Planning Application 2024/93544

Drawing Title/Issue
 Proposed Block Plan

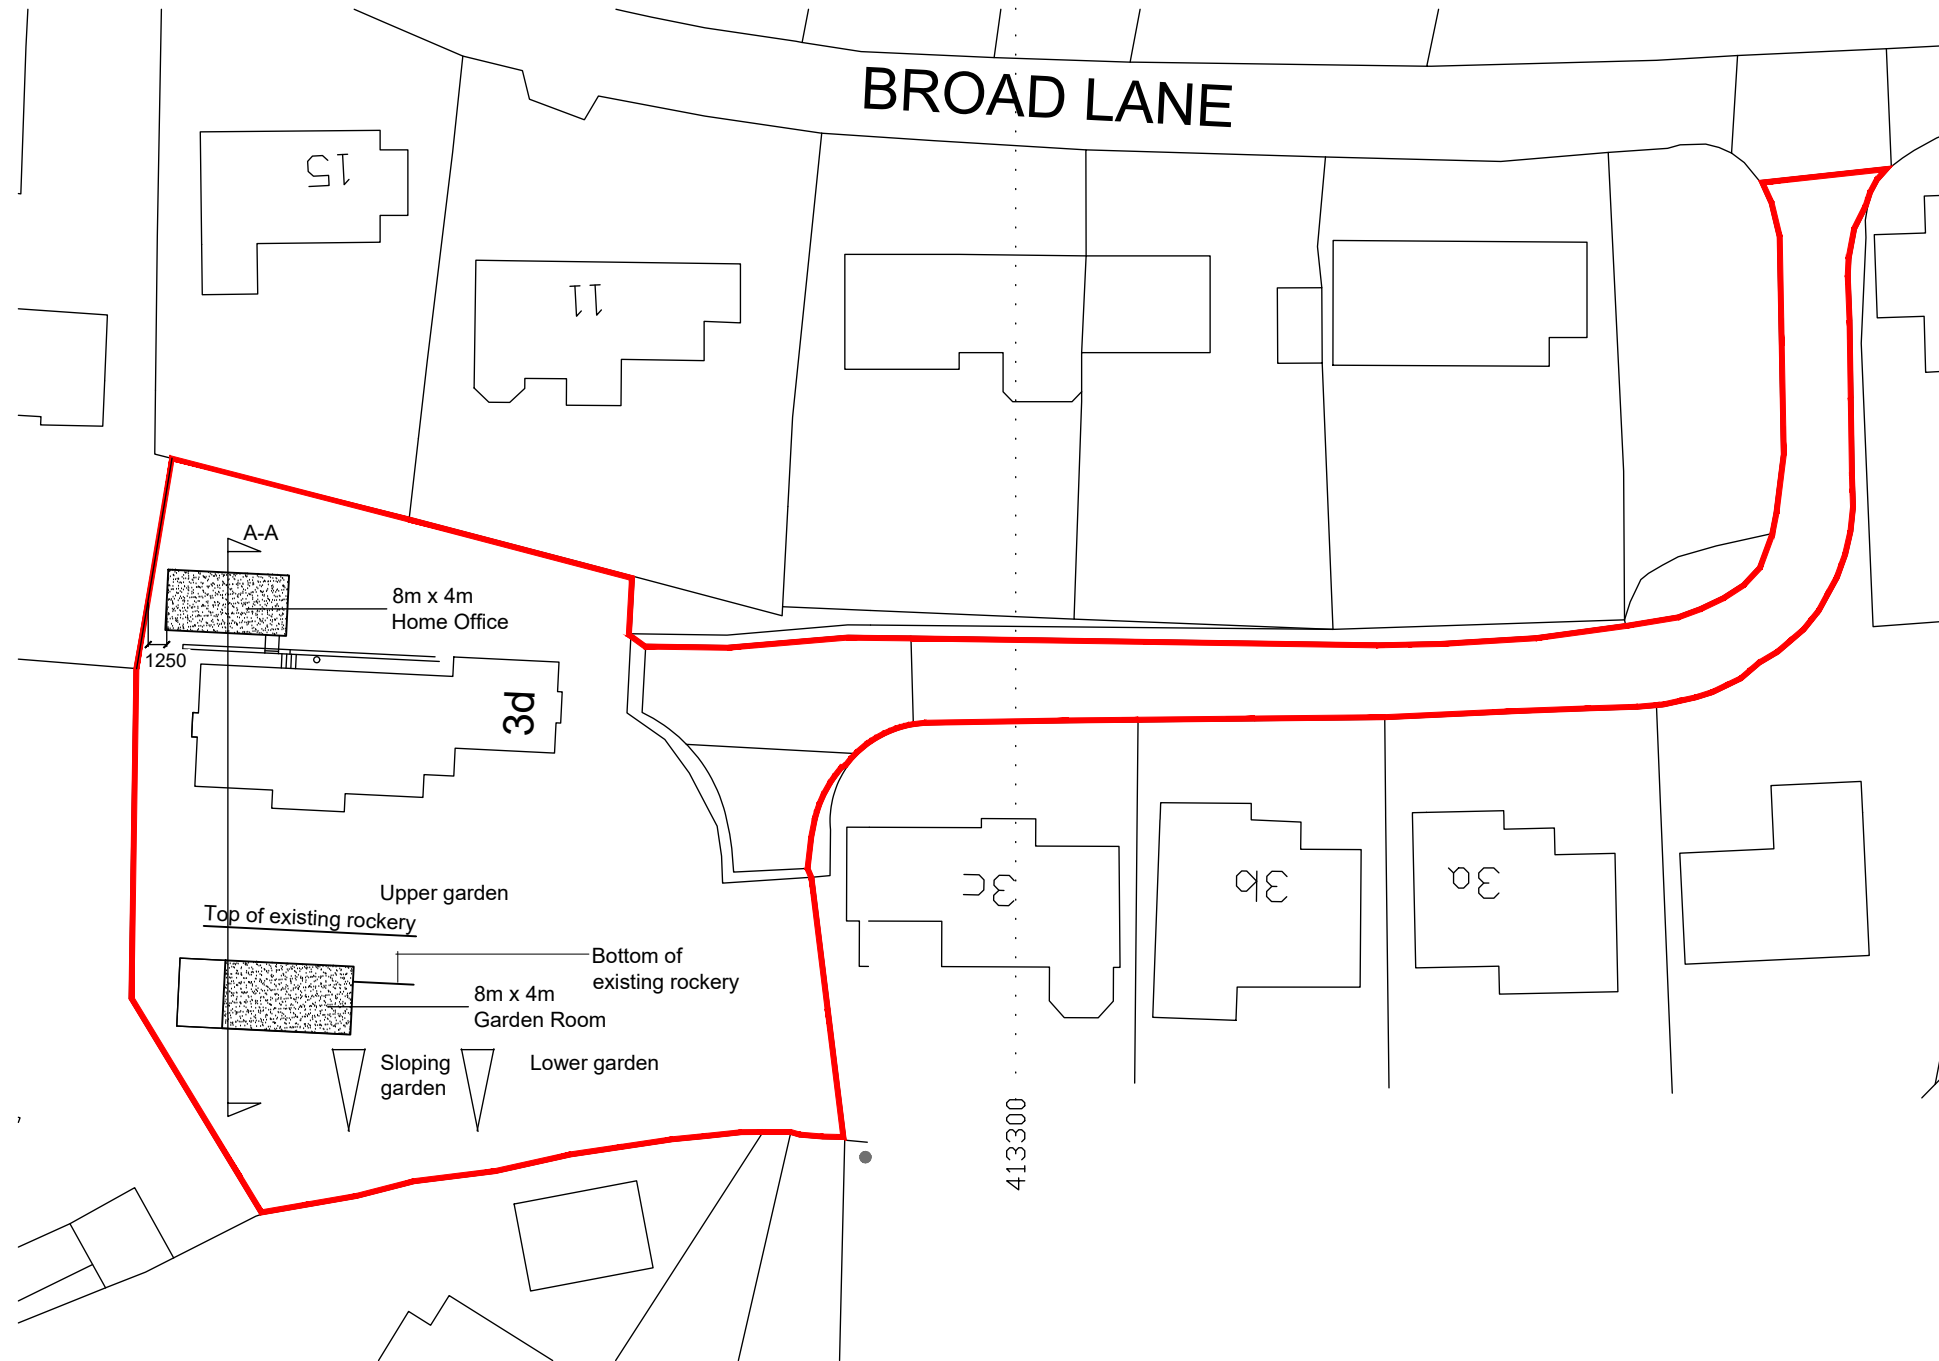
A land drain (contained in a pipe) passes across the lower part of our garden into the plot for 3D Broad Lane. This used to flow straight down hill from an access point just to the South of our boundary with 3D's land but was required to be diverted when 3D was being constructed. This diversion takes the pipe around the Western end of 3D – precisely where the smaller of the proposed pods is due to be constructed.

The integrity of this land drain directly affects us – when it has blocked with rubble after prolonged rain, our garden has flooded. The previous/current owners of 3D have blocked off the access point directly below which makes blockages even more difficult to clear.

We would request that Planners require the Applicant to commission a survey of the drains across the plot and that the drain(s) are preserved/redirected in any ground works.
